ADDENDUM TO DETERMINATION OF NON-SIGNIFICANCE (DNS) SEP19-005

Application No: SEP19-005 (SUB19-002)

Description of Proposal: A SEPA DNS Addendum associated with recent revisions to an application for preliminary long plat approval, SUB19-002. The Applicant requests preliminary subdivision approval to divide the 2.88-acre subject property, zoned R-8.4, into 14 lots with associated infrastructure to support single-family residences. A SEPA Addendum is required to the threshold determination to memorialize the proposed revisions.

Date: November 8, 2023

8/30/23
 JOB NUMBER:
13-118
 SHEET NAME:
SP-01
 SHT **3** OF **10**

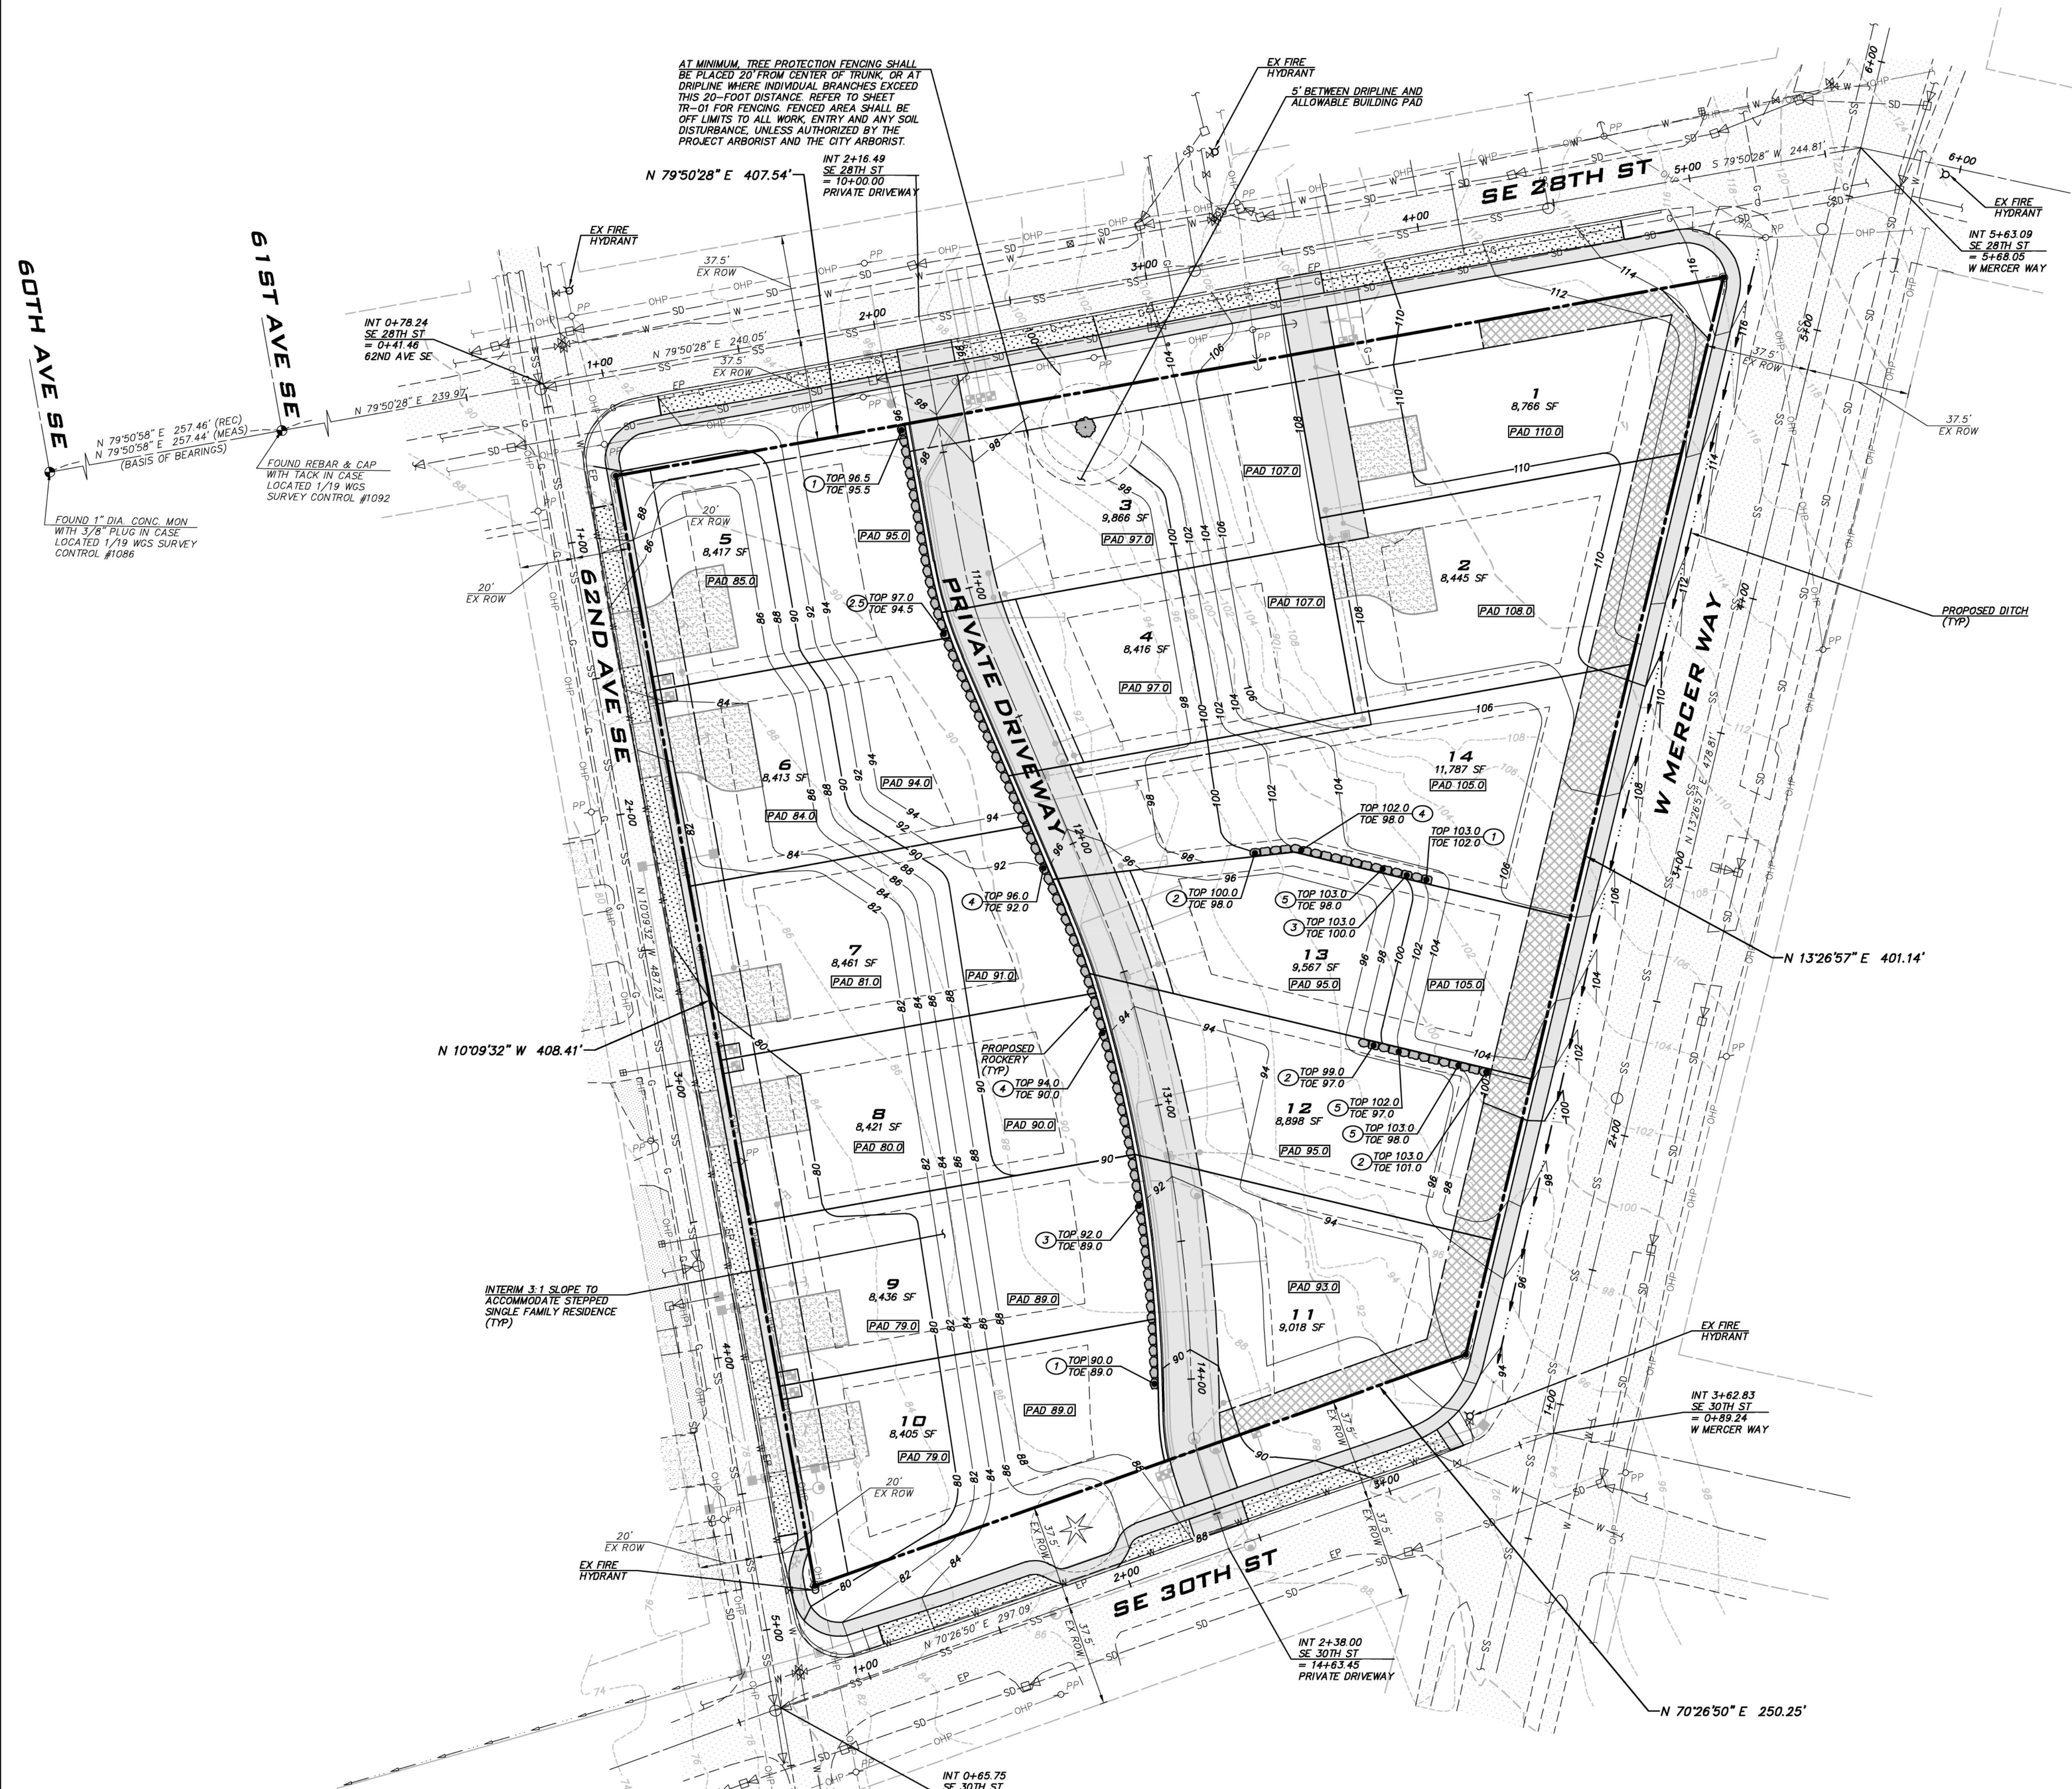
The Applicant, in response to the public comments received during SEPA appeal period, which ended April 5, 2023; no appeals filed, revised the proposed development by adding an internal shared driveway to serve lots 3, 4, 11, 12, 13, and 14, added a shared driveway for lots 1 and 2, and provided a passive open space easement along West Mercer Way, SE 28th Street, and SE 30th Street that will be planted with native vegetation.
